Please ask for: Ms Iqraa Malik
Email: iqraa.malik@terraquest.co.uk
Telephone: 01212341390
Our Ref: R/19/21/HH
Your Ref:
Date: 4th February 2021

Application for Planning Permission for Works or Extension to a Dwelling

Development: Drop Kerb 3 metre wide to enable off road parking
Location: 28 Ash Lane Rustington BN16 3BT

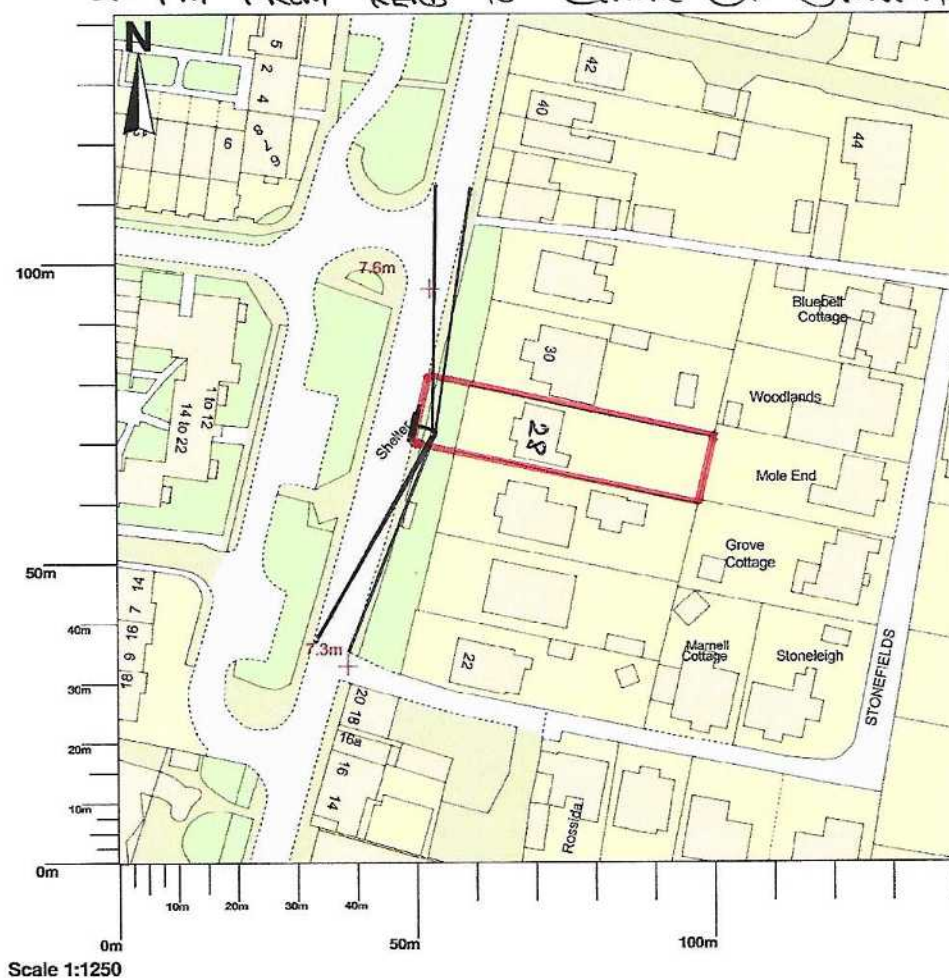
West Sussex County Council require that a visibility splay is provided. A splay is formed for a 30 mph speed limit road by measuring from a point 2.4m back from the kerb edge in the centre of the proposed access. A line should then be drawn from either side of this point for 43 m in each direction to the nearside edge of the carriage way. The splays must intersect land only within the control of the applicant, or within the publicly maintained highway.

The distance will increase with the speed limit of the road. If the road is 40 mph speed limit then the distance should be 120 m either side. For speeds above this please contact West Sussex County Council Highways for advice on what would be acceptable.
